**Consultation Response from KC,
Lead Local Flood Authority****2021/94552 Land at, Barnsley Road, Denby Dale, Huddersfield, HD8 8TS****Erection of 53 dwellings and associated works****Date Responded: 1st March 2022****Responding Officer: Paul Farndale****Responding Ref:**

FURTHER INFORMATION is required in order for the Lead Local Flood Authority to support the application.

BARNESLEY ROAD : DENBY DALE | SITE LAYOUT

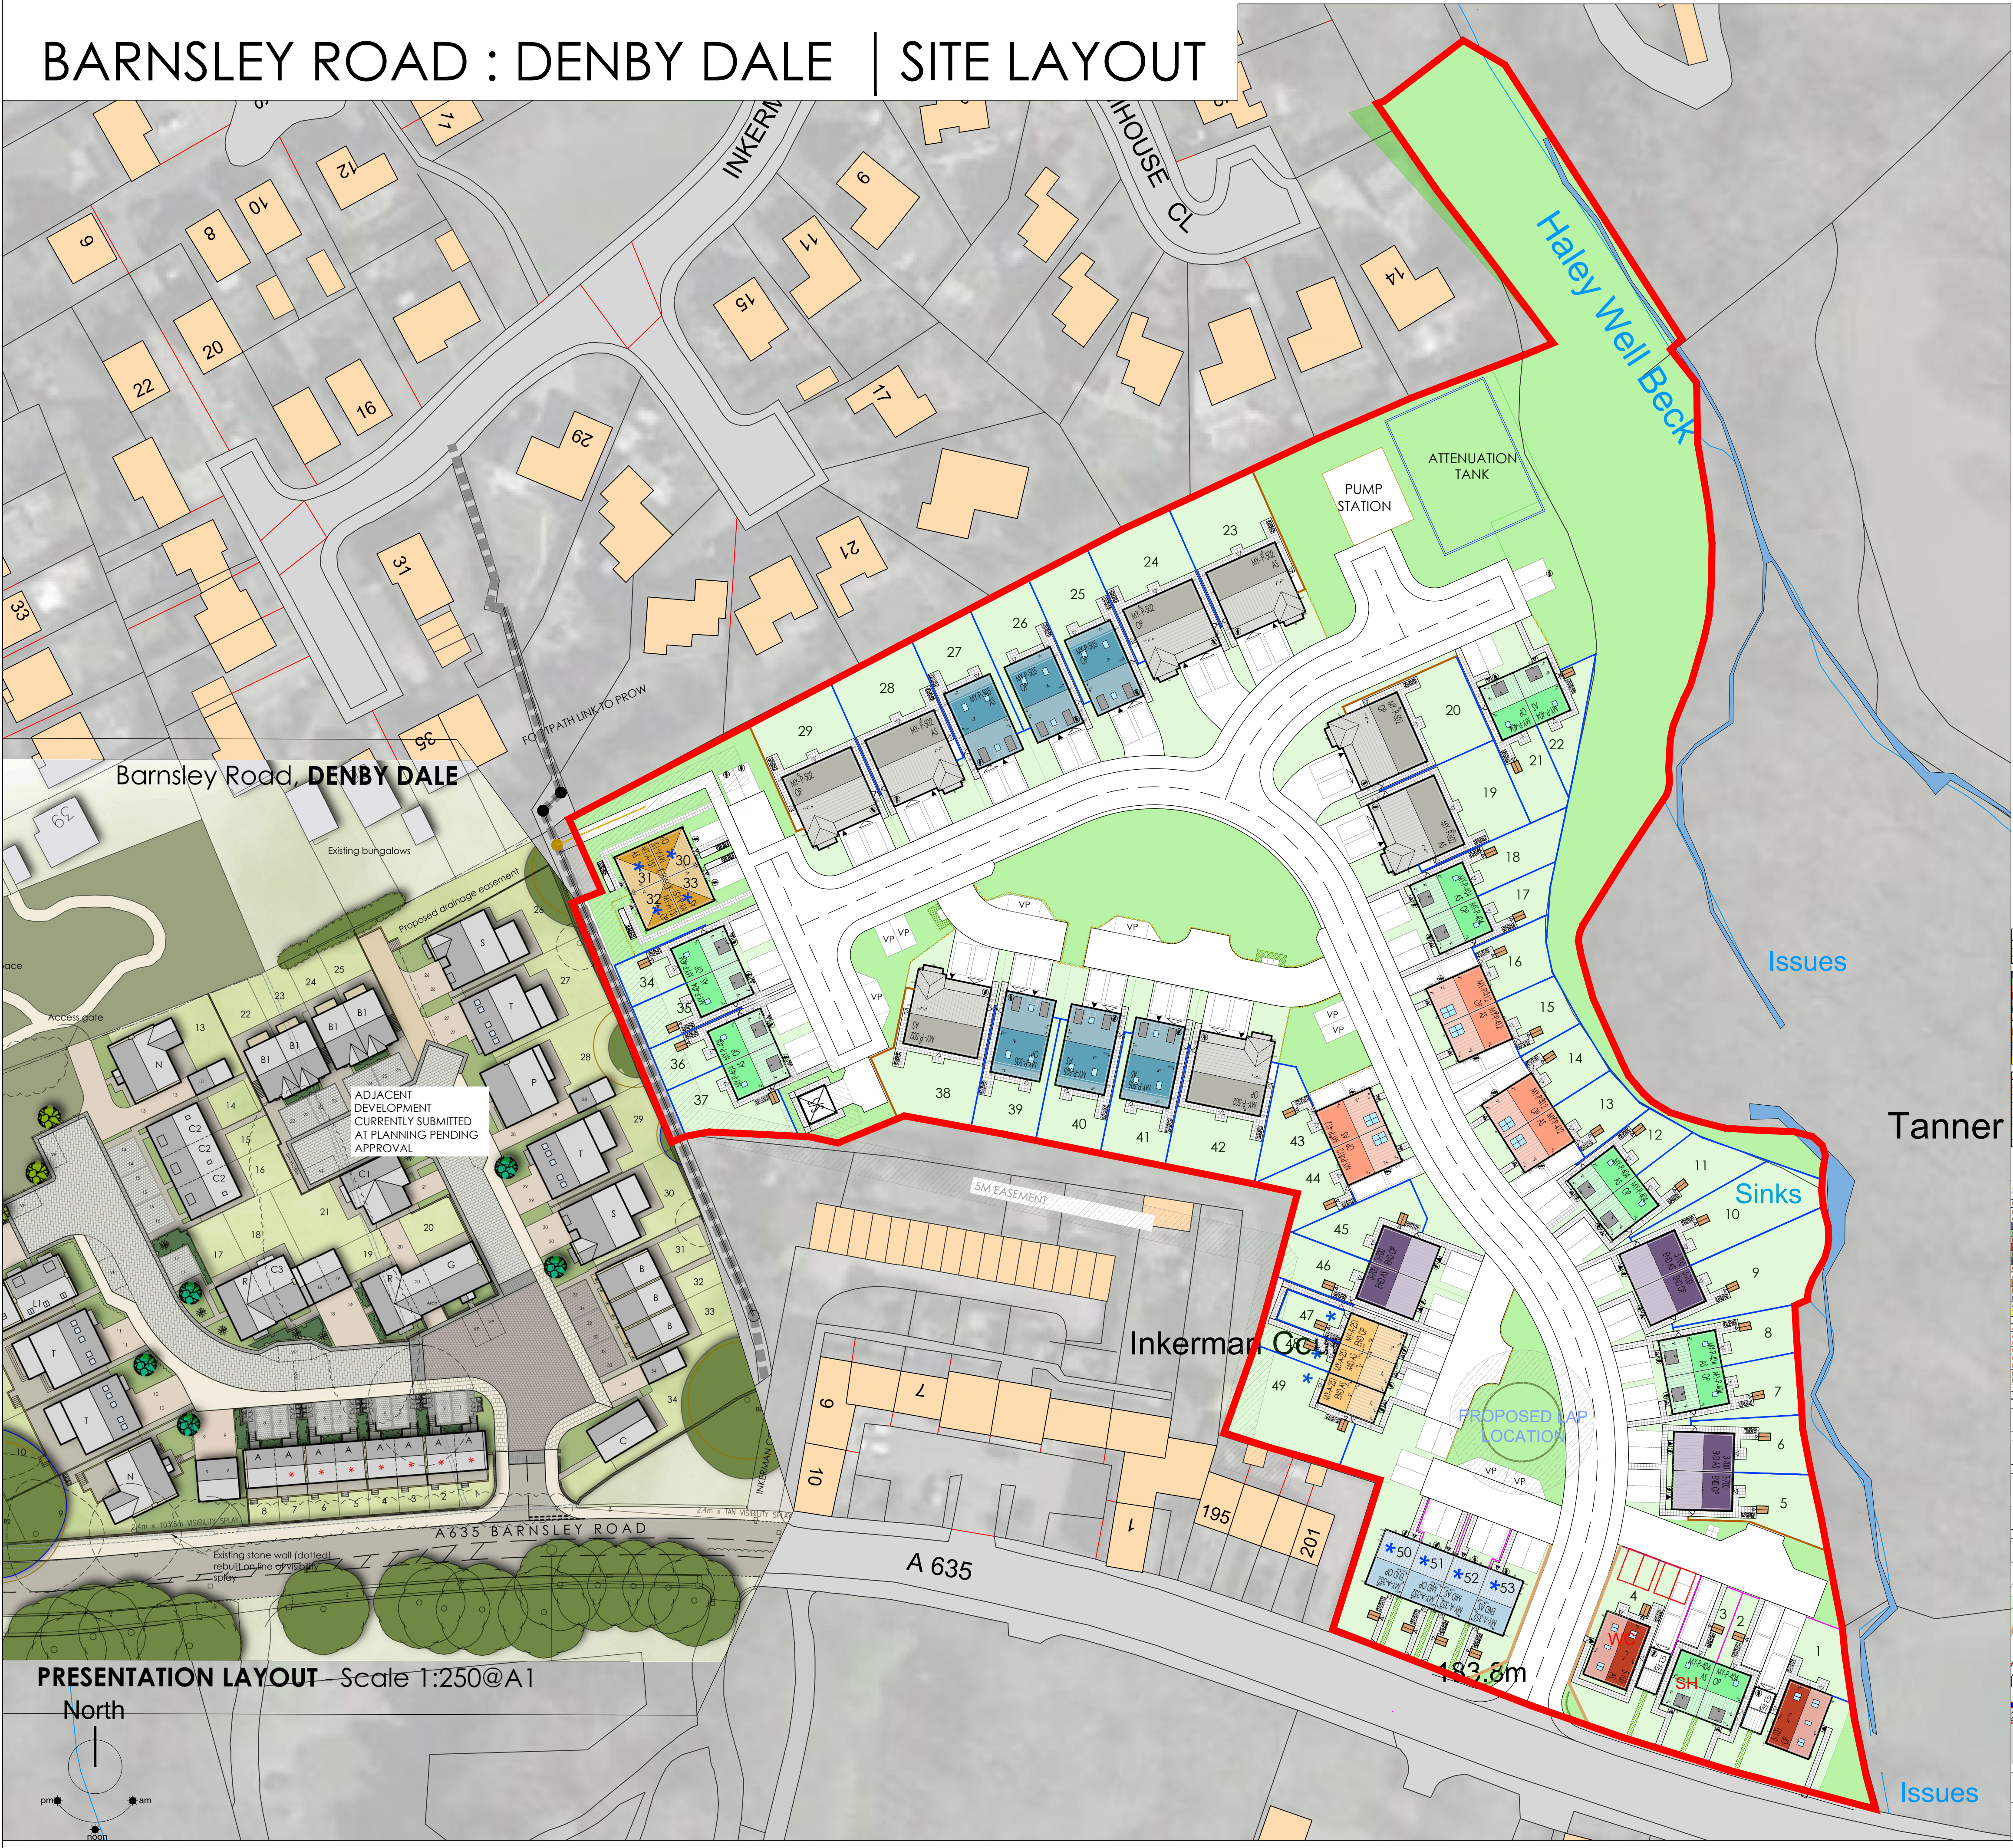
Plots are shown very close to the watercourse which is unmodelled. Plot 1 being the closest. A preliminary analysis of levels either side of the site boundary and into land to the east needs to take

place and contours displayed. Modelling may be required so levels must be taken at frequent intervals. This must form part of the flood risk assessment.
